# CITY OF ALBUQUERQUE

November 14, 2018

RE: **Oso Bio Syringe Line**  
**4401 Alexander Blvd NE**  
**Grading and Drainage Plan for Building Permit**  
**Engineer's Stamp Date 11/1/2018 Disapproved**  
**Hydrology File: F16D003B1**

OSO BIO SYRINGE LINE OVERALL GRADING PLAN		
DRAWN BY:	DATE:	
CHECKED BY:	PROJECT NO. 20190058	SHEET NO. <b>C1.2</b>

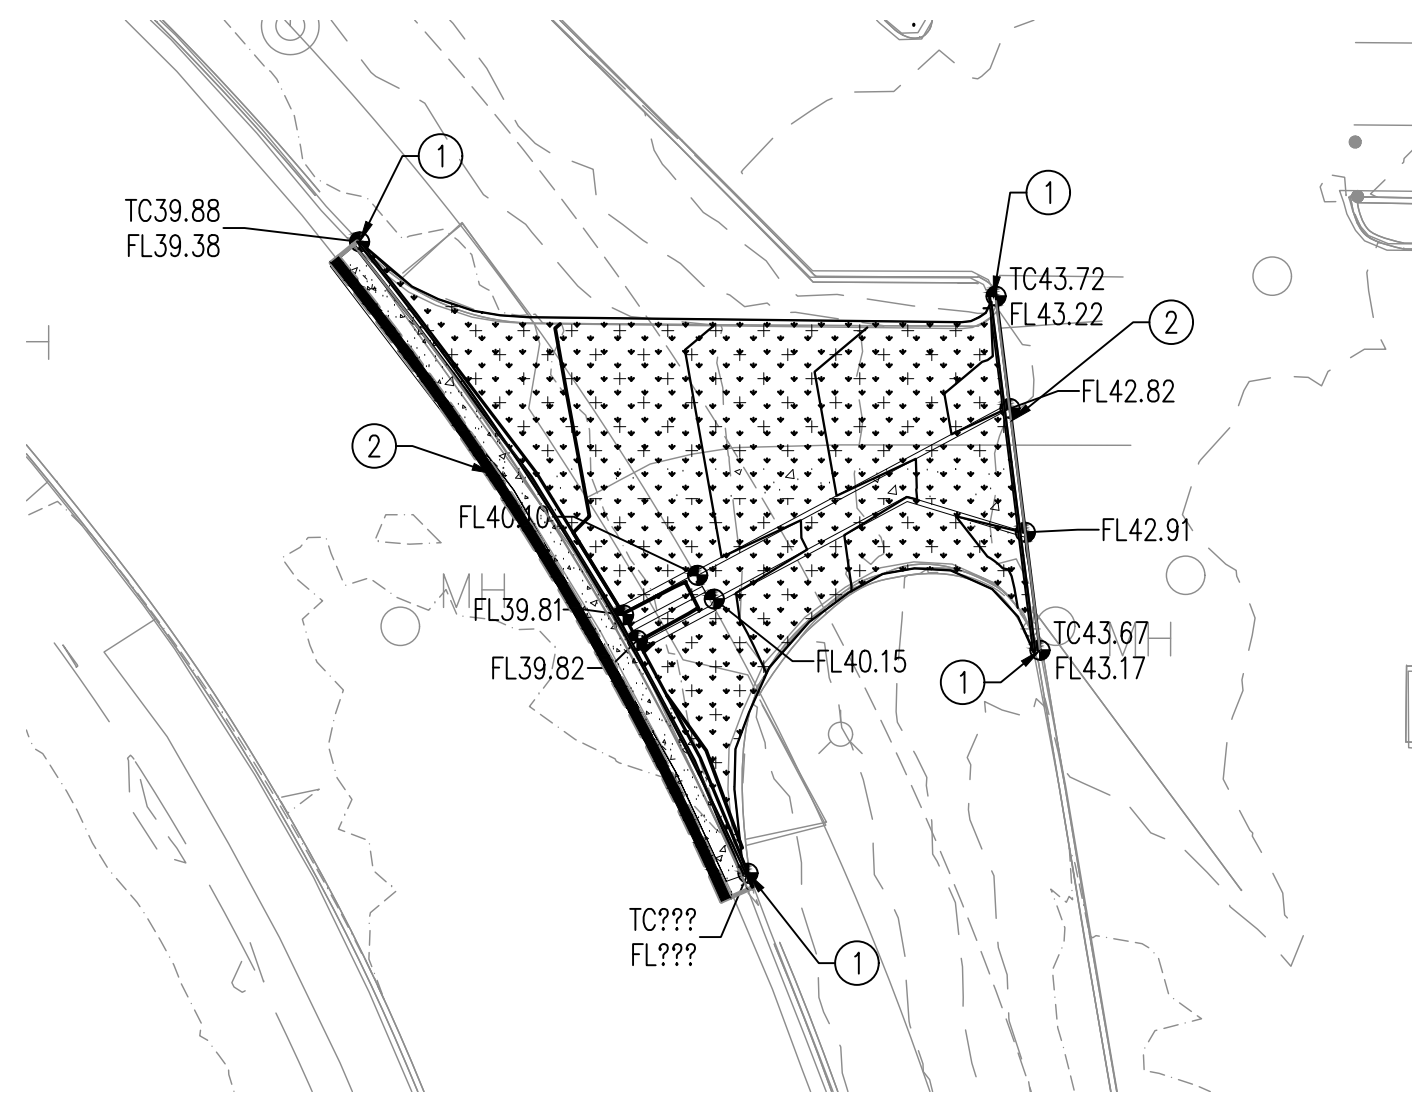
1. In the HEC-HMS Model:
  - a. Per the draft DPM, 6-1(B)(2) *Computation of Time of Computation*, if  $t_c$  is computed to be less than 0.2hrs, than use 0.2hrs. Lag time then becomes  $0.6 * t_c = 7.2$  minutes.
  - b. The inlet elevation for the PVC pipes is specified as 5033' but is 5032' in the plans.
  - c. The outlet elevation for the PVC pipes is specified at 5031.9' but is ~5031' in the plans; also the outlet elevation of the pipes and the Invert-In and Invert-Out of the sidewalk culverts should be specified on the plans.
  - d. The bottom of pond is defined as 5031' in the model, but shown as 5031.5' on the plans.
2. The proposed 100-yr WSEL needs to be shown on the pond in plan view.
